Written representation on the proposed rights of way over the World Heritage Site at Stonehenge, A303 Highways England
from Myra Bennett, British Horse Society Wiltshire, County Access Officer
Registration Number 20017562

General remarks on the importance of the proposed new rights of way

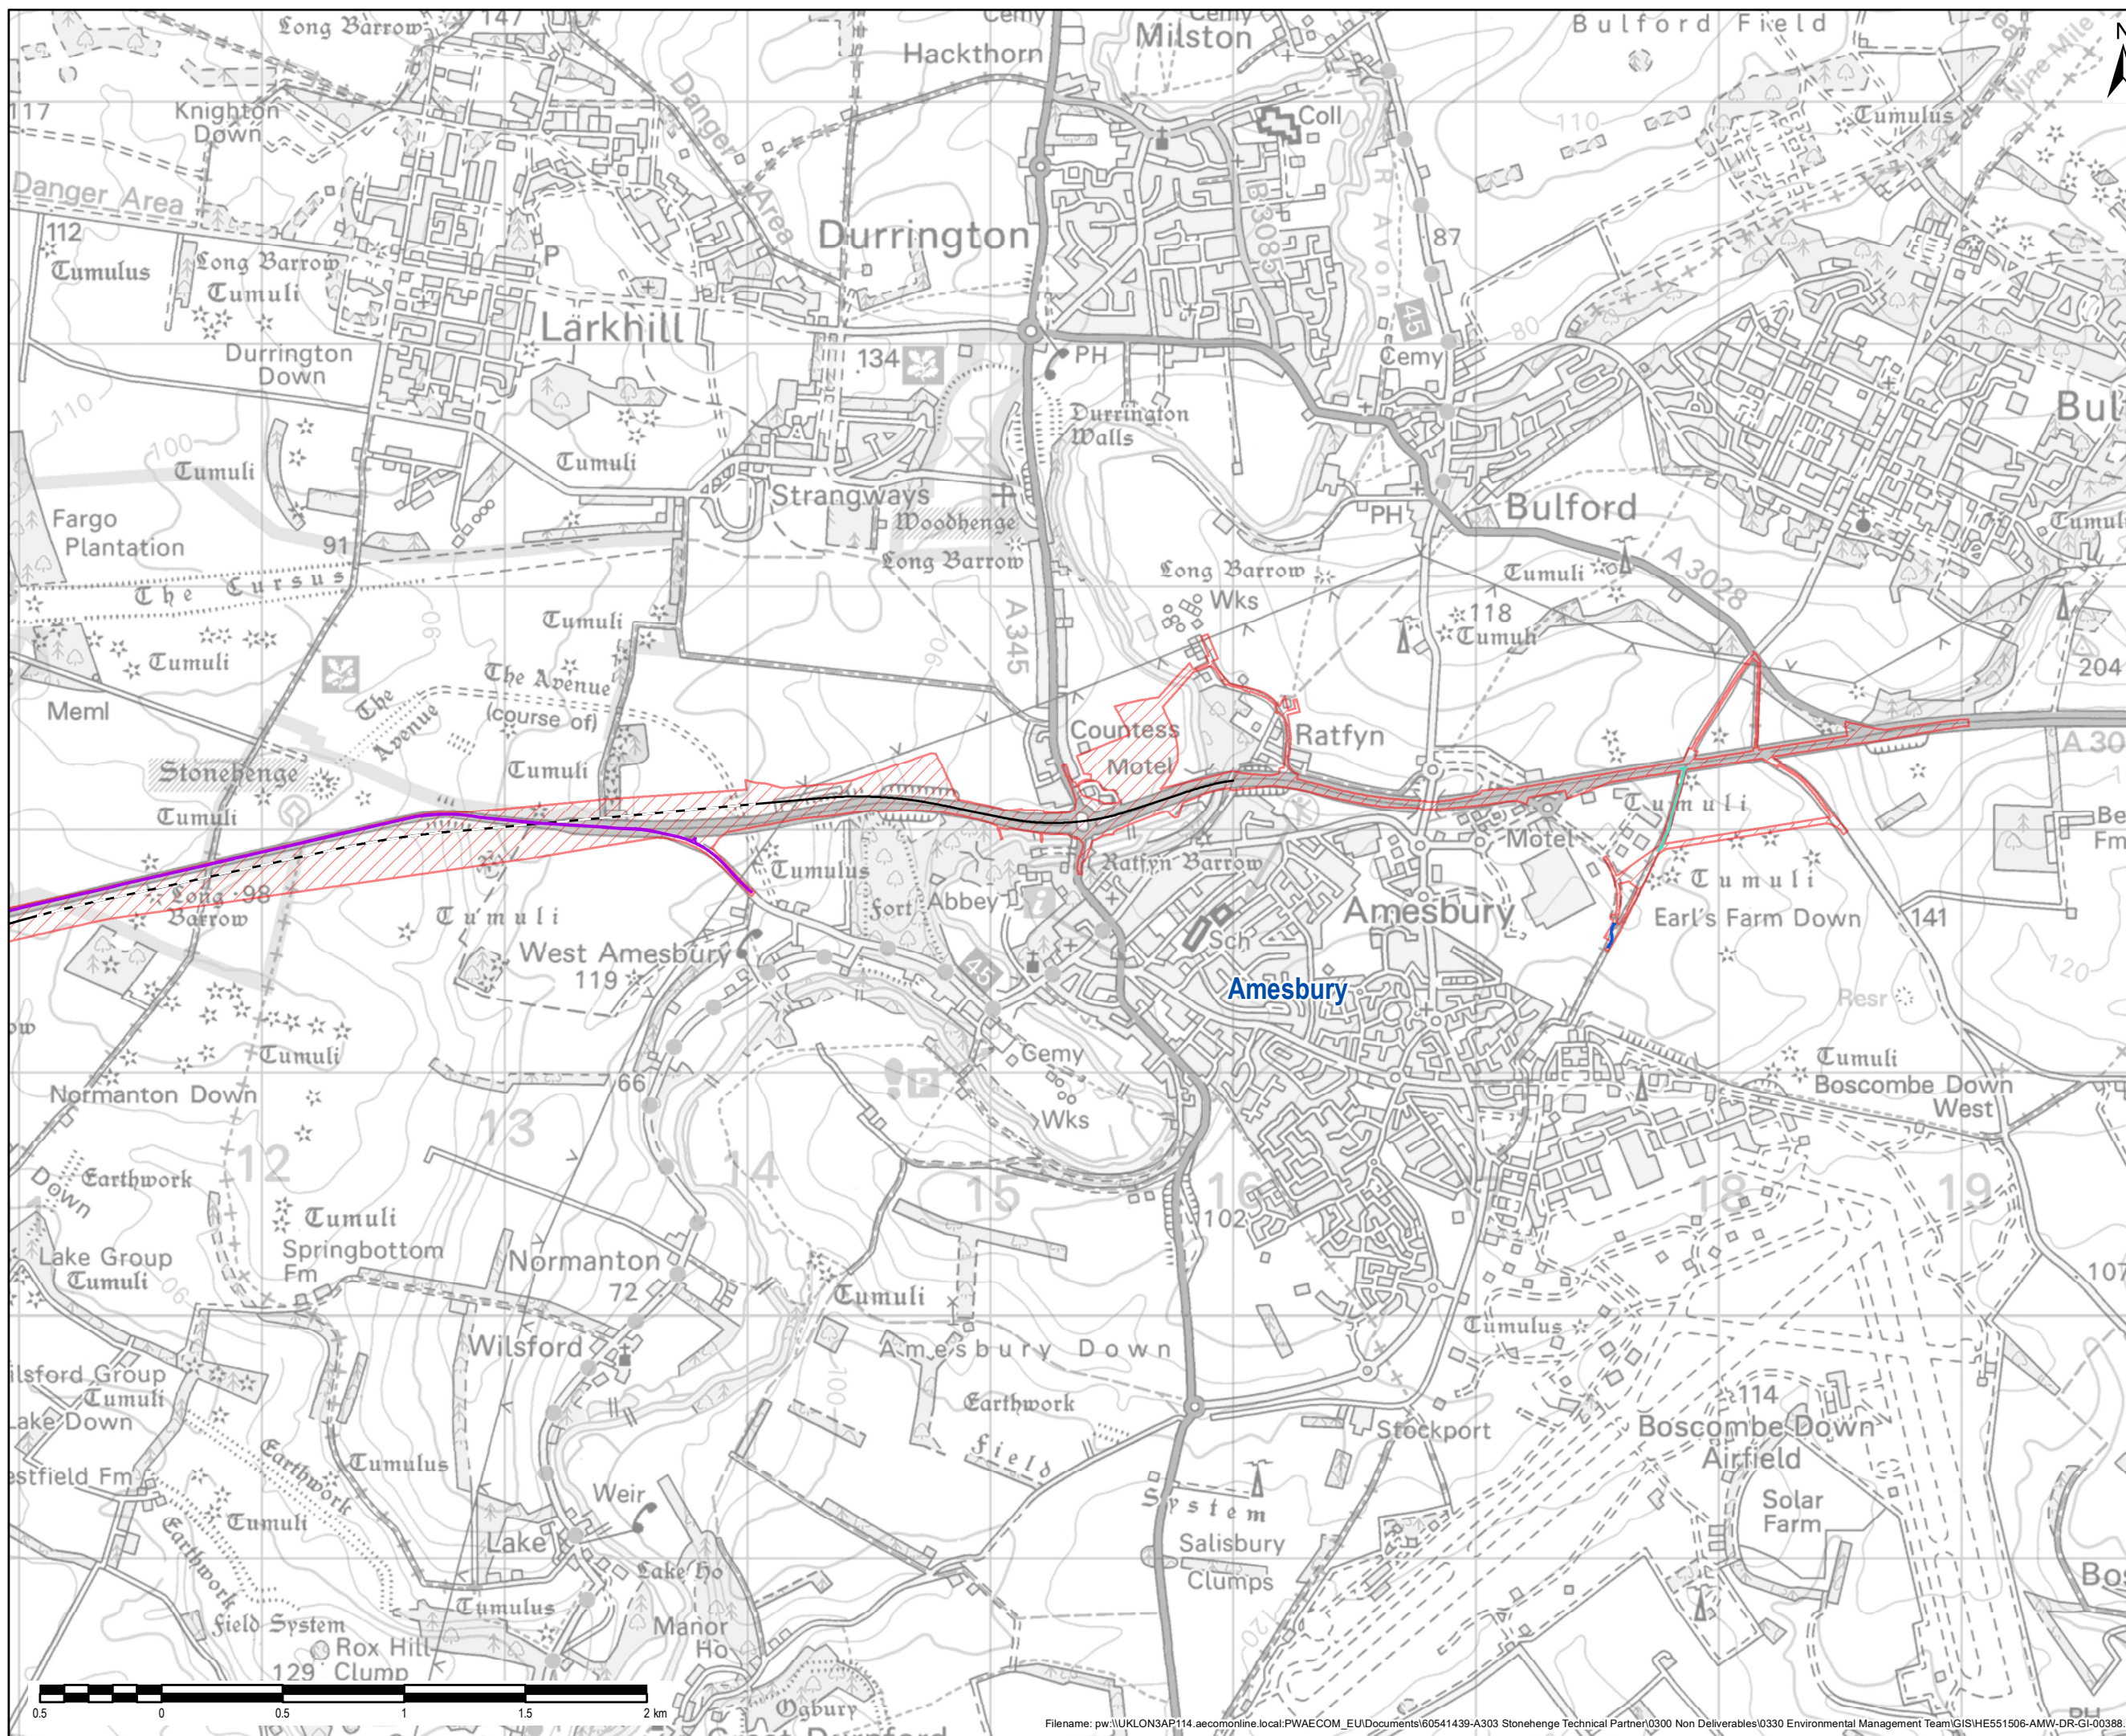
1 There needs to be a safe tunnel or bridge crossing at Yarnbury Castle, which will otherwise be too dangerous for NMUs to cross.

2 There needs to be a safe road crossing over the A360 for the new bridleway proposed to run up the south side of the new Winterbourne Stoke approach road, to take it over the A360 and on towards Green Bridge 4.

A bridge or tunnel is needed, rather than the currently proposed traffic lights, as otherwise horse riders and other NMUs will be forced to queue to cross a dangerous road.

3 The new RB (created from the route of the old A360) running south down the eastern side of the new route of the A360 apparently goes to a dead end at the A360.

From the new Longbarrow roundabout it needs to connect with existing RB BSJA9 on the west side of the A360. A suitable road crossing over the A360 is thus be required to achieve this.

Alternatively, a new RB could be constructed down the west side of the A360 (rather than the east side) to connect directly with RB BSJA9 (with the route of the old A360 either closed or left as a dead end).

4 The new RB (created from the route of the old A360) from Green Bridge 4 running north towards the Visitor Centre on the east side of the A360 apparently goes to a dead end.

It needs to be connected to the course of the old A344, now an RB, in a way which doesn't involve NMUs clashing with users of the Visitor Centre car park.

5 Byway AMES12. This provides an important access route onto the WHS and across it to Salisbury Plain and beyond for walkers, cyclists, horse riders and carriage drivers both from the south and the north.

A safe crossing over the A360 at Druids Lodge would make this route much safer and more attractive for NMUs travelling north to Salisbury Plain and south to the Wylde Valley over the WHS.

6 Byway AMES11. This provides the ONLY access onto the WHS for walkers, cyclists, horse riders and carriage drivers travelling north over the WHS from the Woodford Valley and Salisbury to routes over Salisbury Plain via Larkhill or via Winterbourne Stoke. Equally it is the only link for NMUs travelling south towards the Woodford Valley and Salisbury from the north. The new RB route from Stonehenge Cottages into Amesbury does not provide direct access to existing off-road connection to the Woodford Valley and further south.

AMES11 is currently shown as a dead end on the project plans (before it meets the new RB formed from the old A303). This means that NMUs will be sharing the route with motorised traffic travelling in both directions and attempting to turn round at various points along the route. This situation is, again, far from ideal and needs to be addressed, see 7 below.

7 Motorised use of Byways AMES11 and 12 will deter use by many vulnerable NMUs of the off-road connectivity offered by the scheme (horse riders of all ages and child/family cyclists are particularly vulnerable to motorised traffic, and the rutting of surfaces caused by motorised use is incompatible with cycling and in many cases horse riding). This outcome would significantly diminish the advantages intended to be offered by the scheme both to NMU leisure tourism and local community off-road access.

A solution must therefore be put in place by the Applicant to avoid this clash of interests between users of the byways.

New NMU routes running alongside both the byways might be a possibility, or a TRO on AMES11 and a parallel route for NMUs alongside AMES12.
